CITY OF ALBUQUERQUE

October 26, 2017

RE: **4936 Pan American**
Grading and Drainage Plan
Engineer's Stamp Date: 10/23/17
Hydrology File: F17D032

DATE	10/11/2017	SHEET	C1.1
SCALE	AS NOTED	OF	2

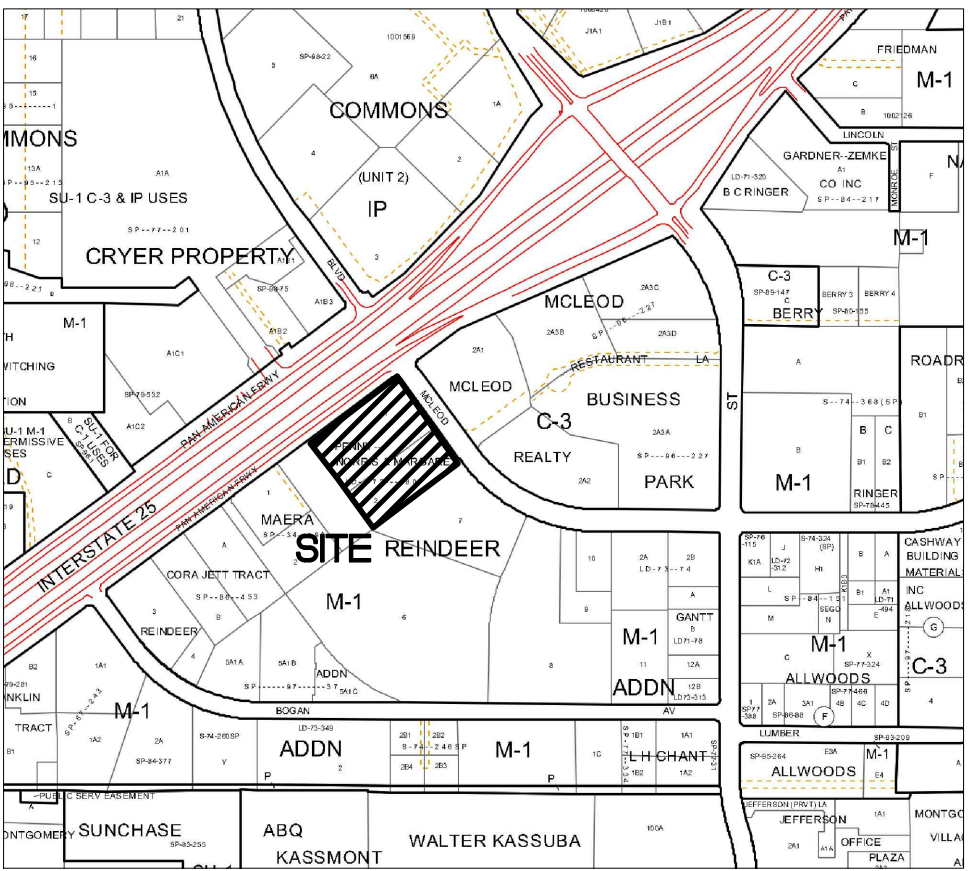
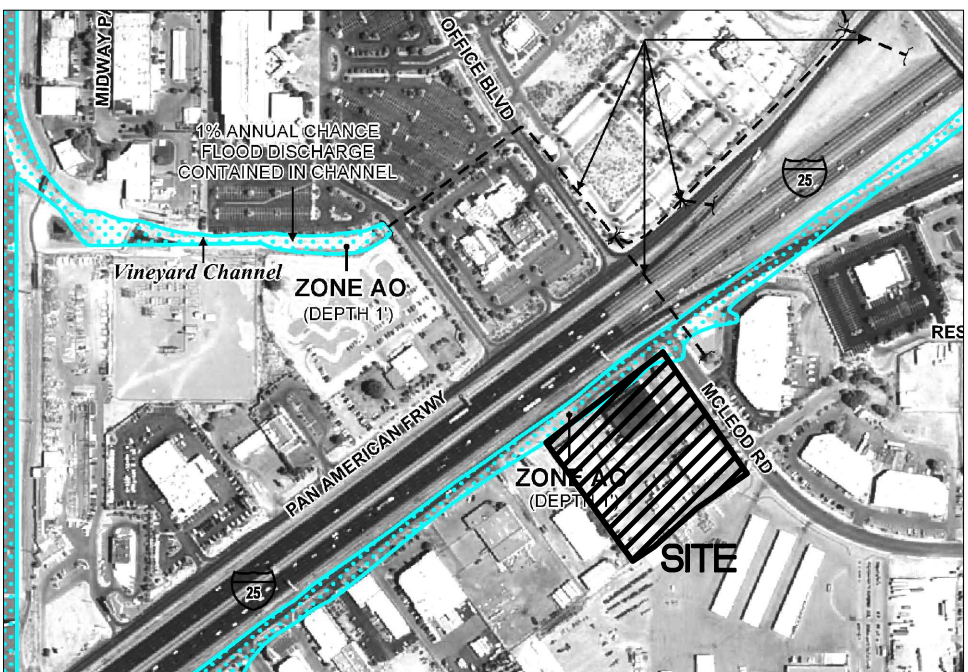
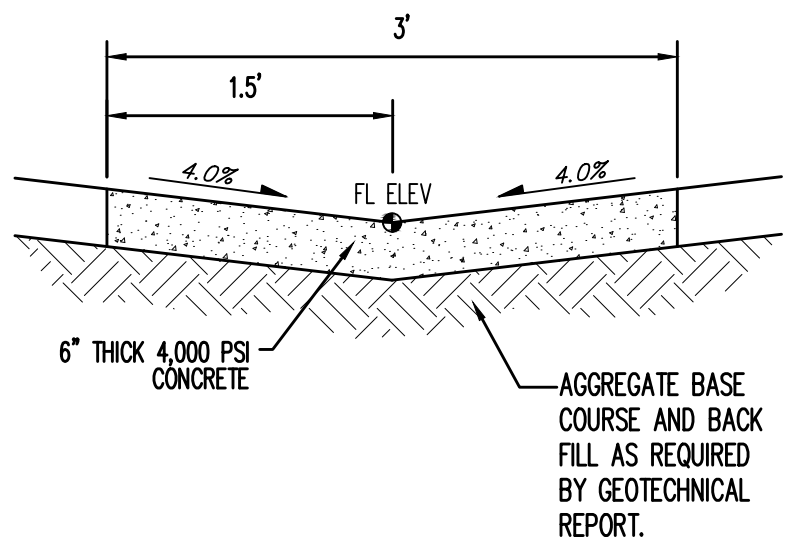
1. Written concurrence must be obtained from NMDOT D3 Drainage that this project can proceed. Please contact Tim Trujillo P.E (TimothyR.Trujillo@state.nm.us).
2. Update the statement under the FIRM viewports to state that a portion of this project is located in a floodplain (AO-1').
3. How much fill/cut is being placed in the floodplain? Quantify the cut/fill volume exclusive of work in the DOT ROW and show where the displaced volume will be provided. The concern for the City is that the floodplain is being filled and displaced into the adjacent properties- mainly the DOT ROW, but also the adjoining parcels north and south.

4. The site must be platted.
5. Payment of the Fee-in-Lieu is required for the first flush bypass volume (51CF x \$8.00/CF, per sheet C1.3).
6. How does the roof drain? Include clarifying language, flow direction, soffits, gutters, etc...
